**PLANNING REF: P/167/21/RES Land South of Summer Lane and West of
Pagham Road, Pagham**

**APPLICATION RESPONSE - HOUSING STRATEGY AND ENABLING MANAGER ARUN
DISTRICT COUNCIL**

Rev.	Description	DATE	DB / CB
Date		Nov' 21	
Drawn By/Checked By		DY / HJE	
Scale		1:1250 @ A2	
Revision			
Project	Land West of Pagham Road Pagham		
Title	Northern Affordable Housing Plan		
Dwg#	21.129.66		
Status	Planning

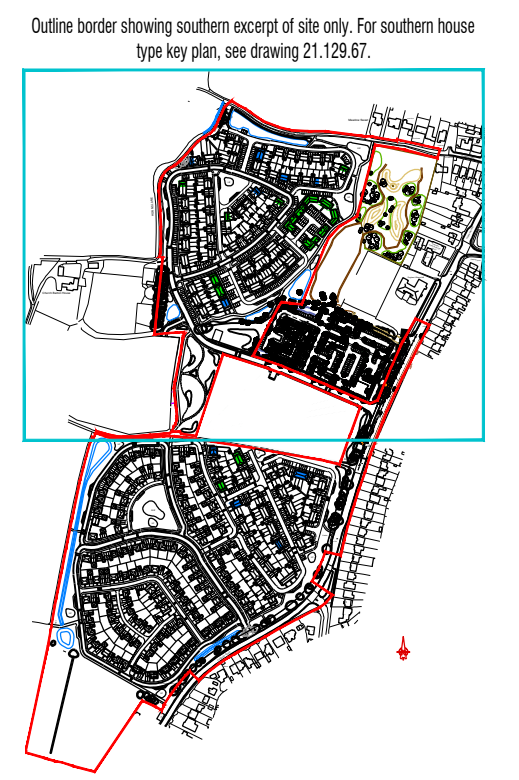
However, we have concerns regarding clustering of the affordable homes particularly in respect of the rented homes and would like to see the plan revisited to better distribute the affordable homes and ensure there are no clusters which total more than 10 dwellings. The cluster of nos.132-163 is of particular concern.

We object to the application in the current form as we would anticipate a more equitable distribution of the affordable homes.
